Please ask for: Sian Eggington
Email: sian.eggington@terraquest.co.uk
Telephone: 0121 2341390
Our Ref: P/45/20/HH
Your Ref:
Date: 28th May 2020

Application for Planning Permission for Works or Extension to a Dwelling

Development: Replacement of outbuilding
Location: 9 Manor Park Pagham PO21 3JS

PROPOSED PLAN
PROPOSED ELEVATIONS
SITE PLAN

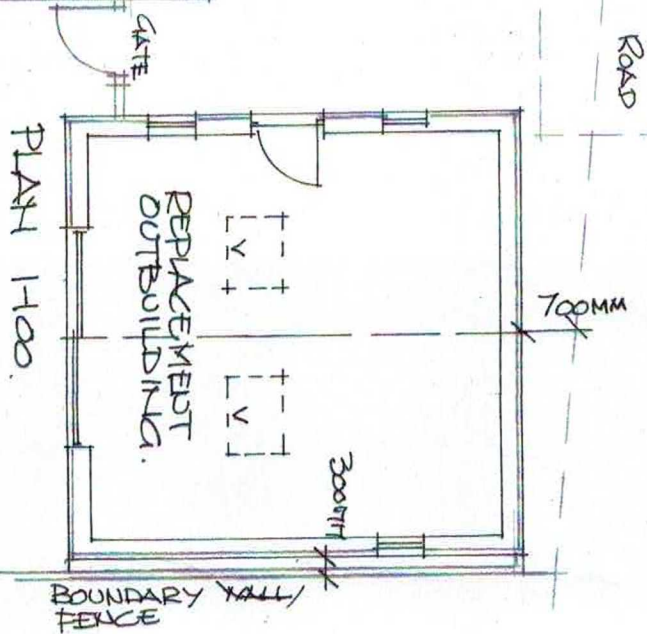
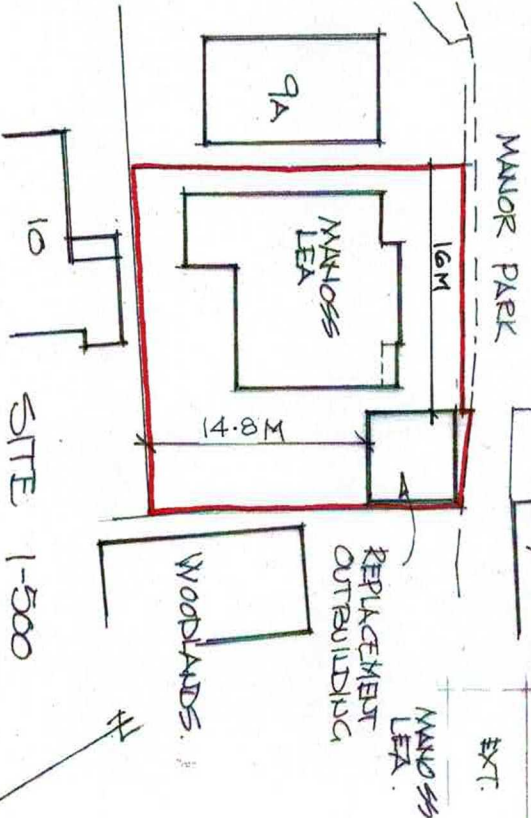
Block Plan: You are required to have another dimension to the other side boundary. With your permission we can add this for you.

Scale: The plans do not measure to there stated scales. Please amend.
